Some very significant concerns about the East Park Energy proposals are still unresolved. As well as areas that remain undefined, they have also made substantial changes to the scheme from the one initially submitted, all at a very late stage of the examination.

Figure 2-4: Proposed Site Access

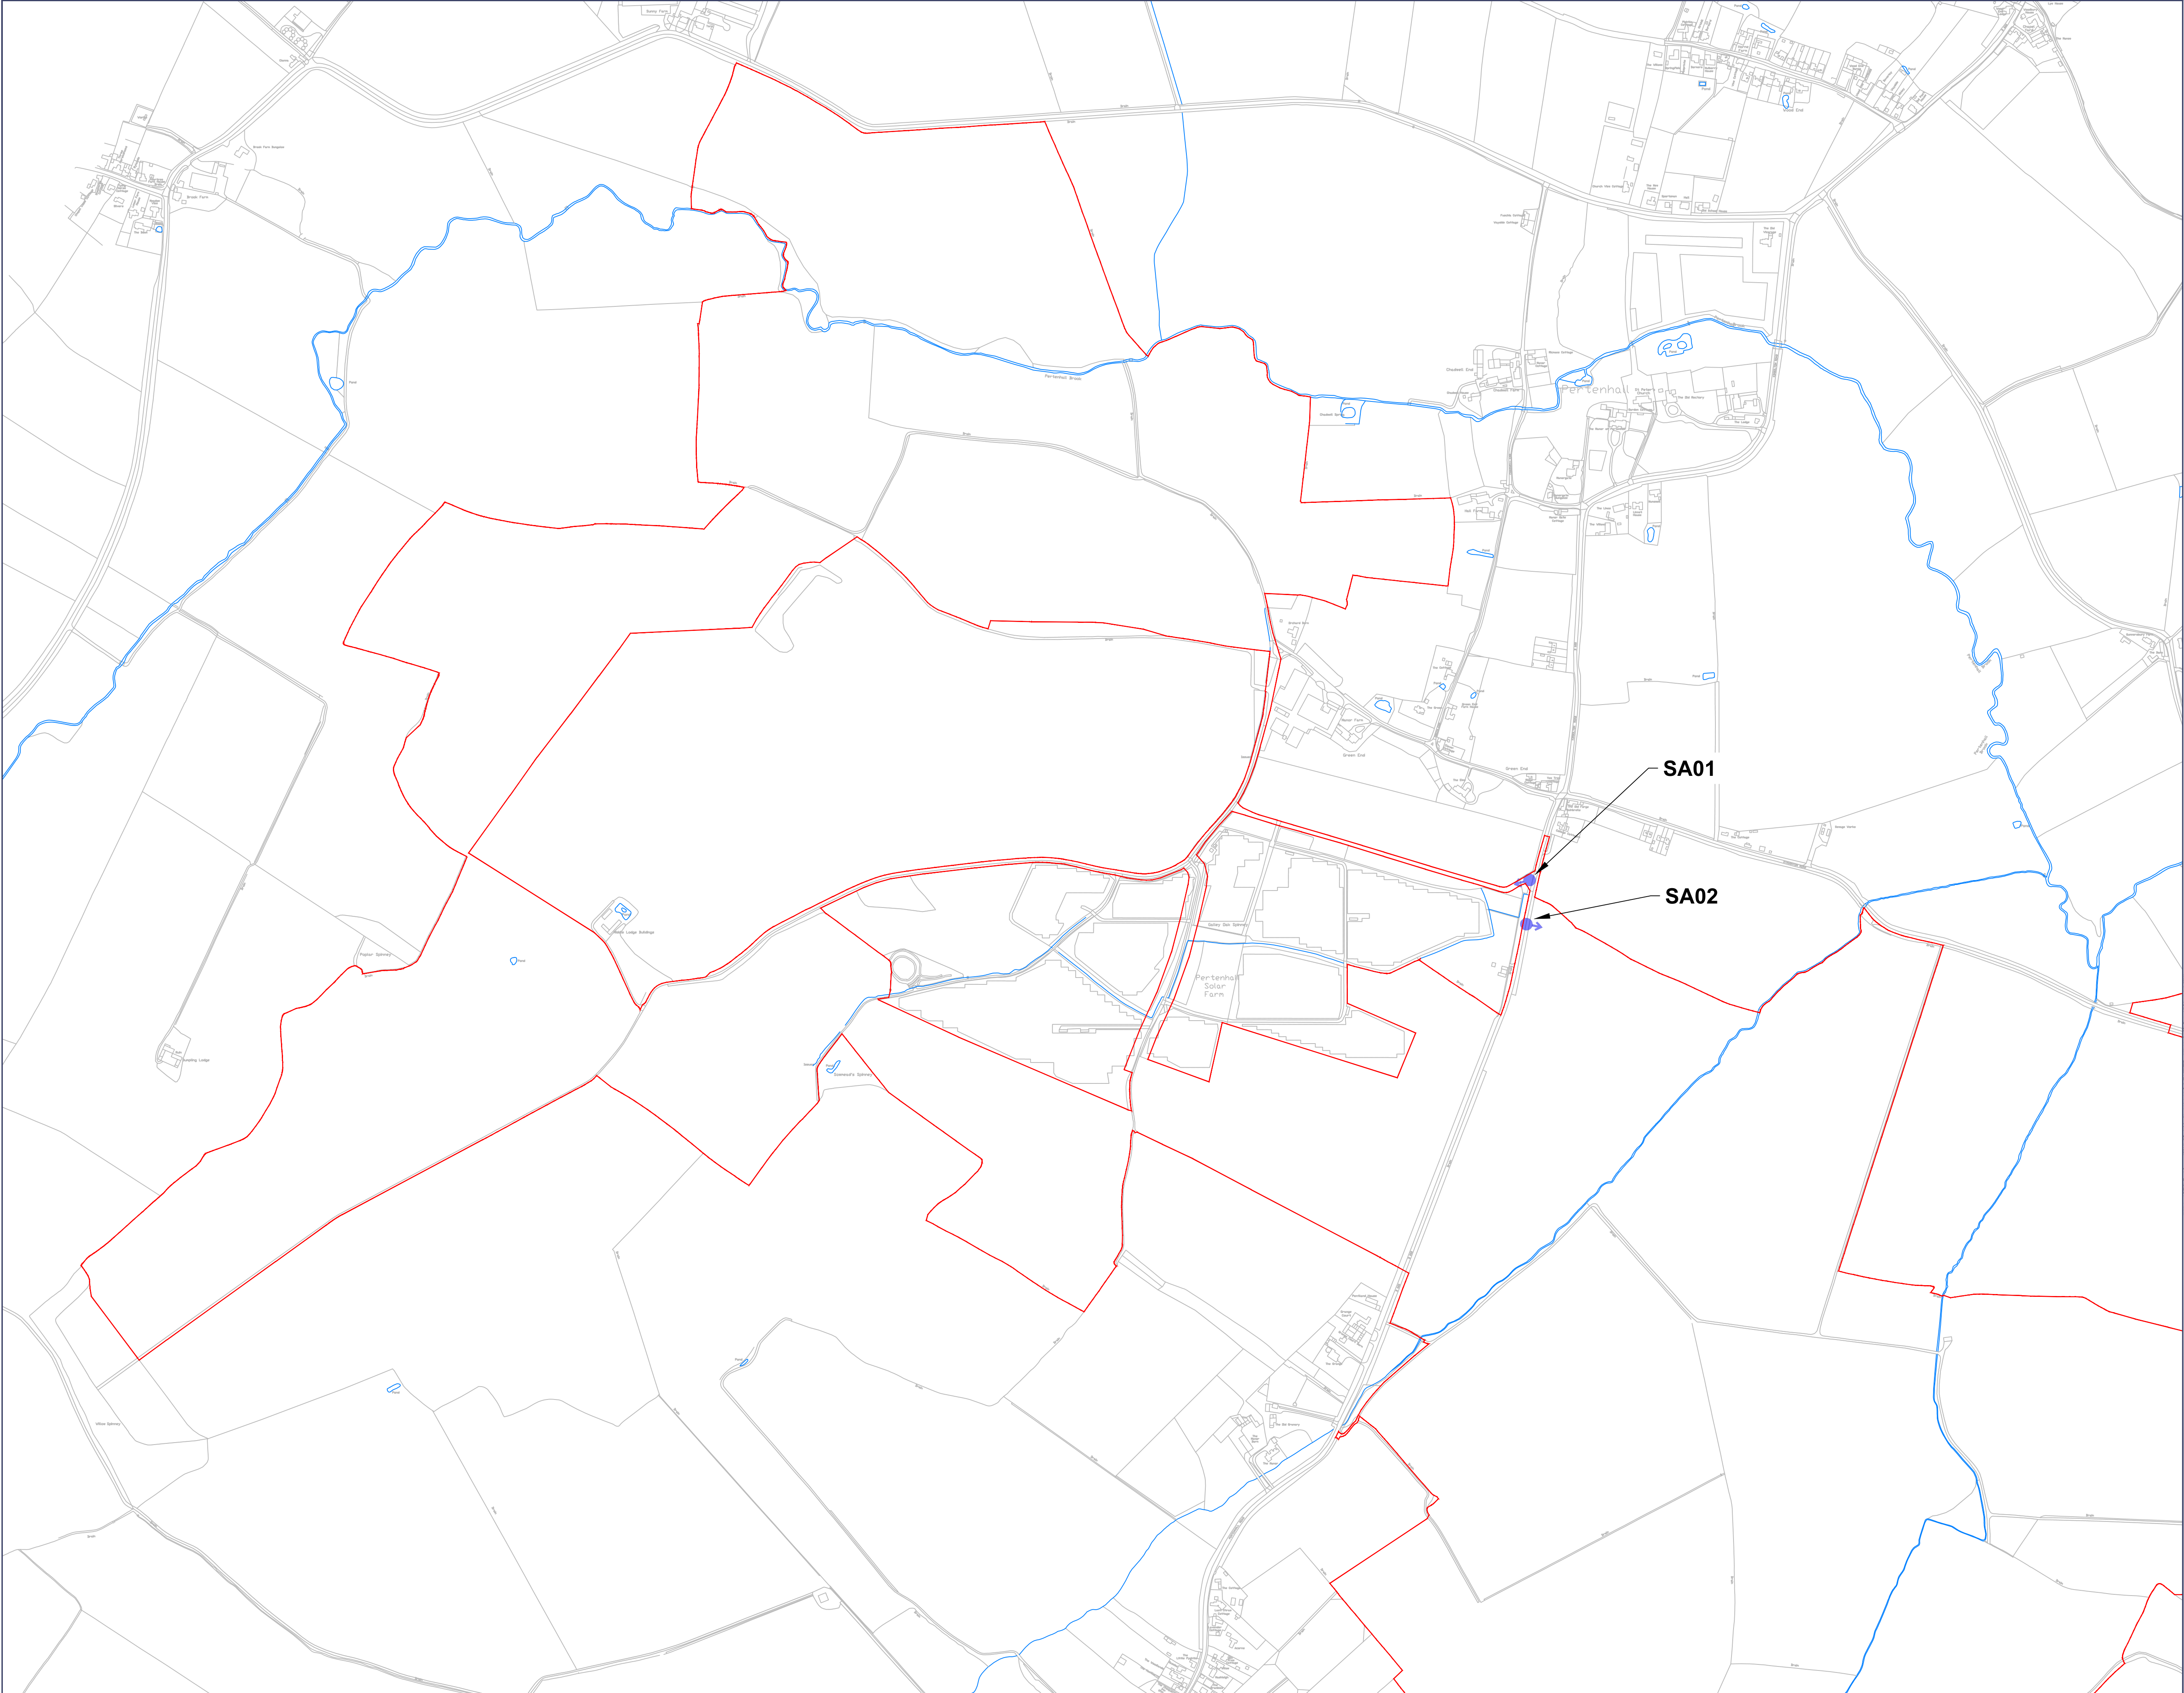
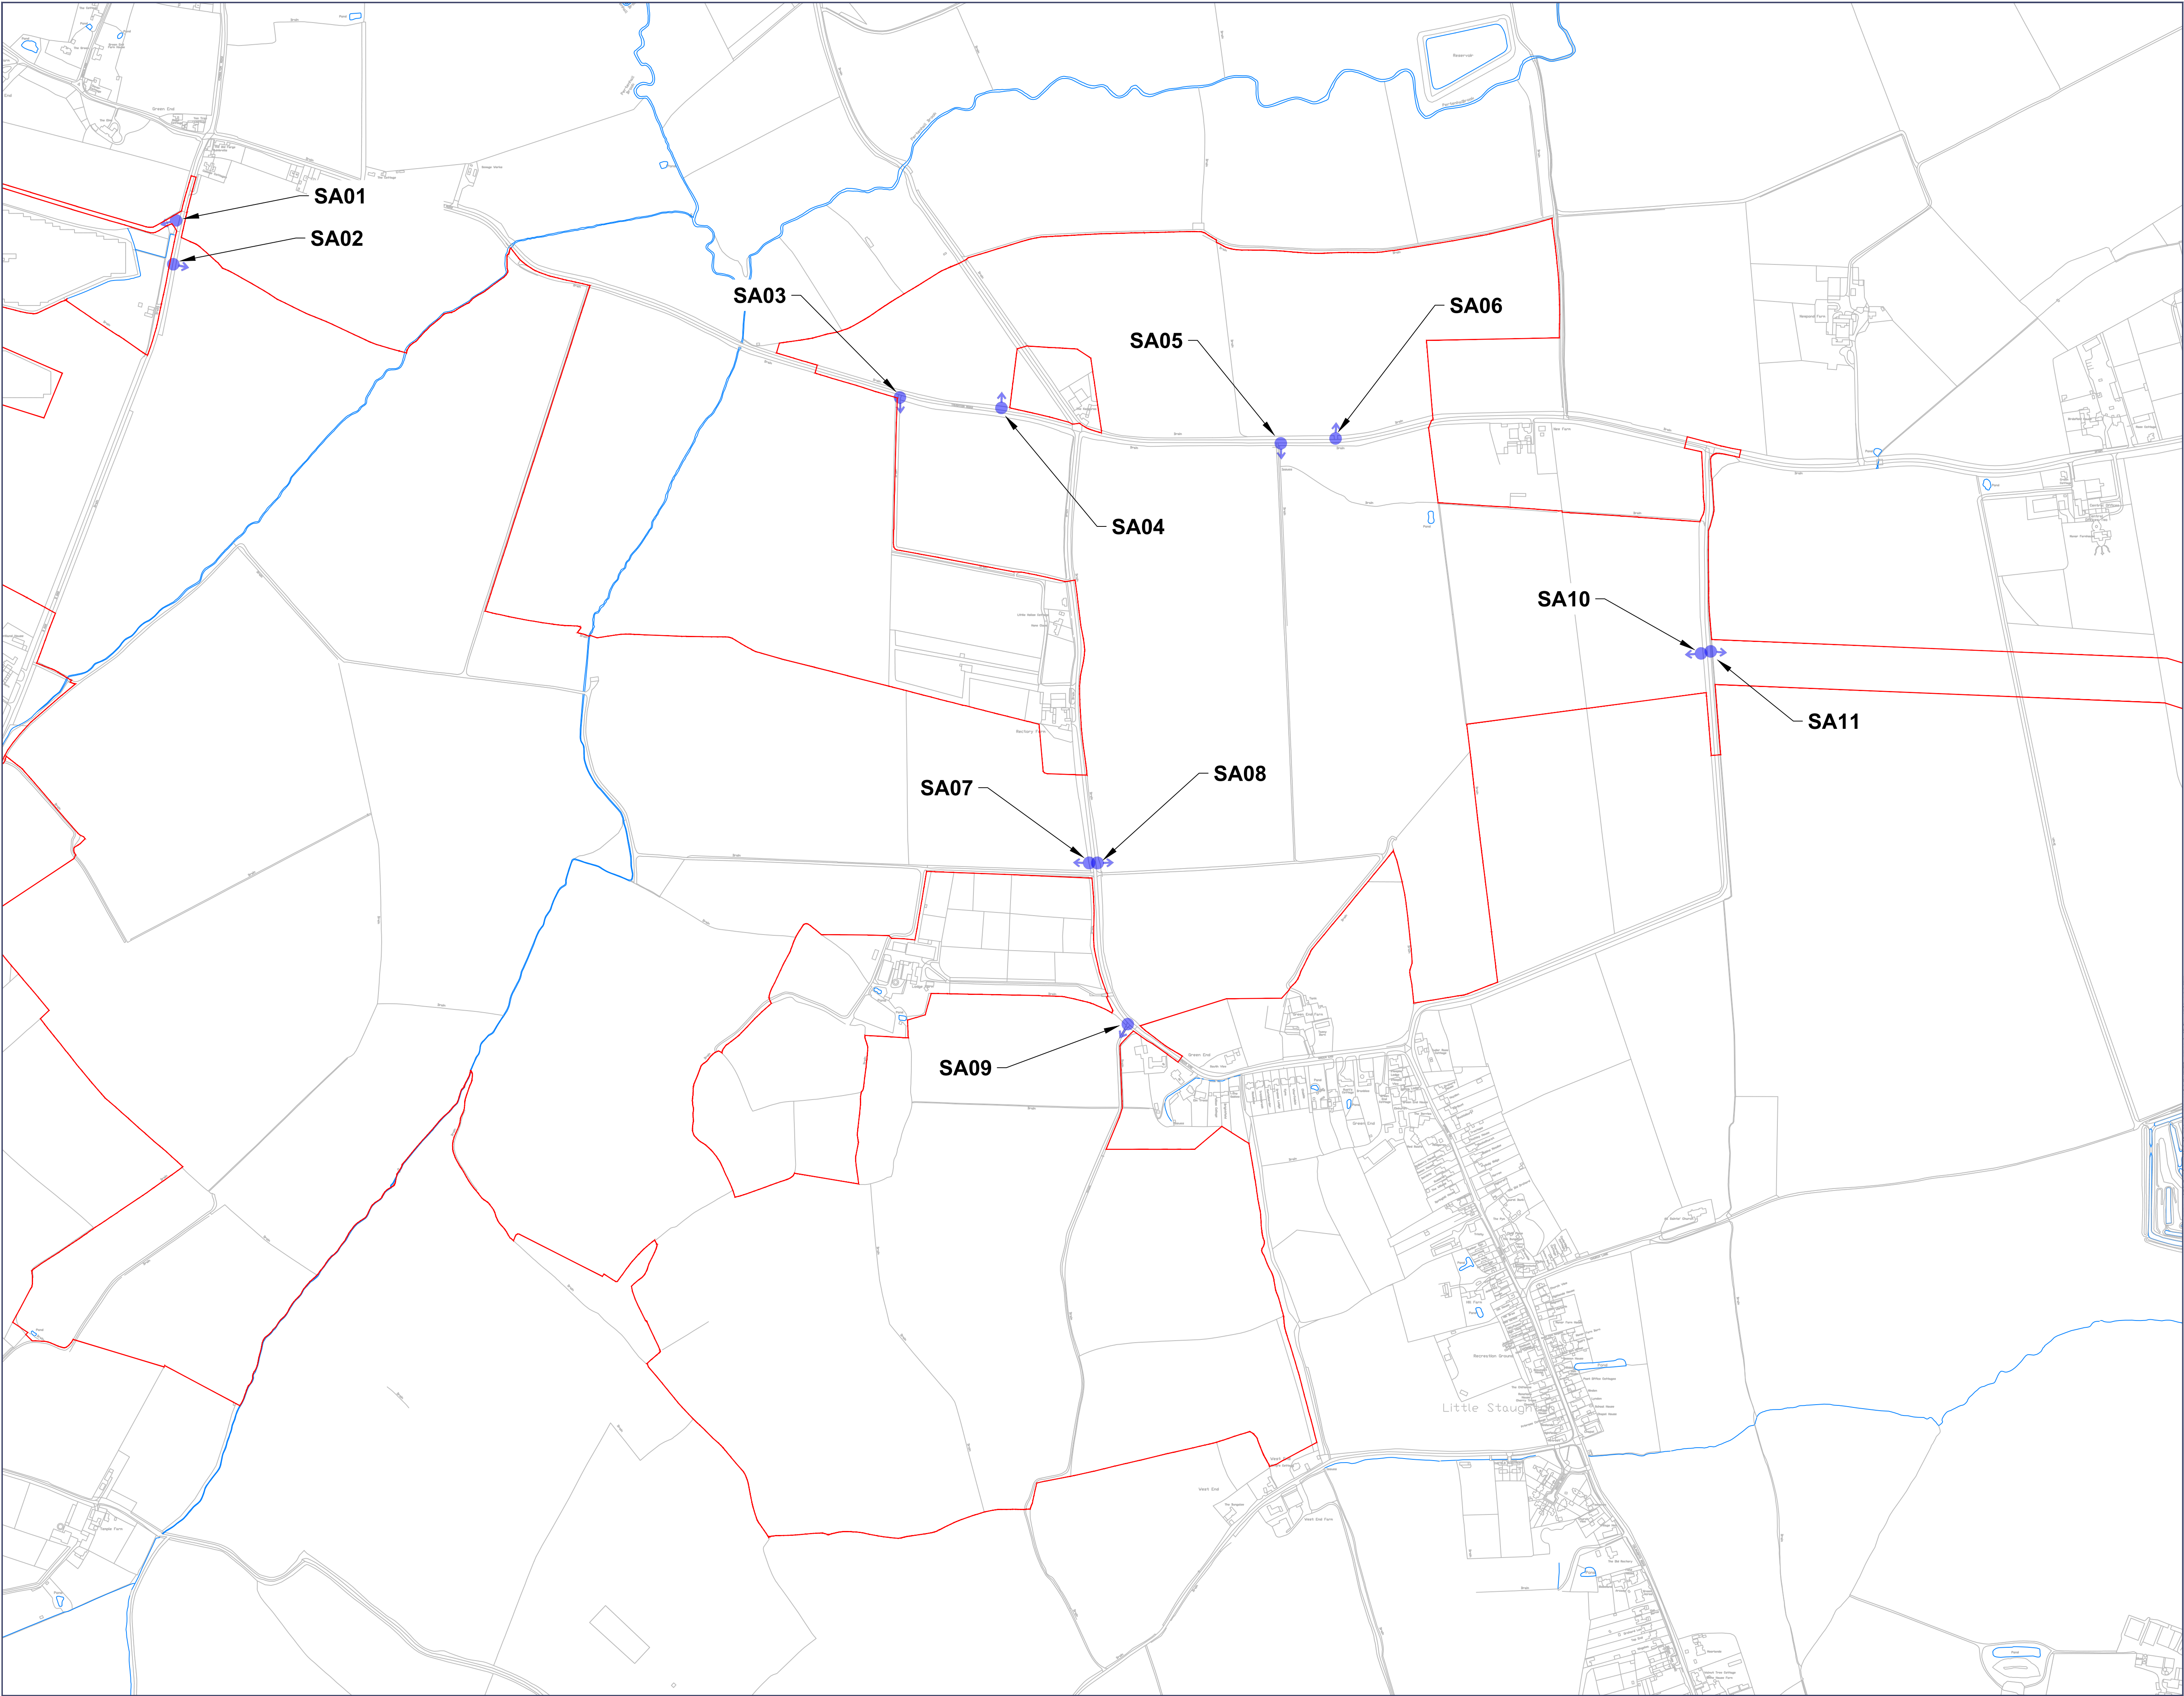
- Their proposed single-point site entrance for both HGV and staff vehicles remains non-mandatory and without any detail of enforcement regimes or even management plans. Despite their statements that narrow country lanes will not be used, there are still multiple site access points shown on these roads.
- There are significant errors in the estimated number of HGV movements which have not been satisfactorily addressed by the Applicant.
- There are doubts about the effectiveness of the proposed carsharing /minibus use as a voluntary method of reducing workforce traffic. The site plans still show car parking areas at every site with no detailed traffic management plans.
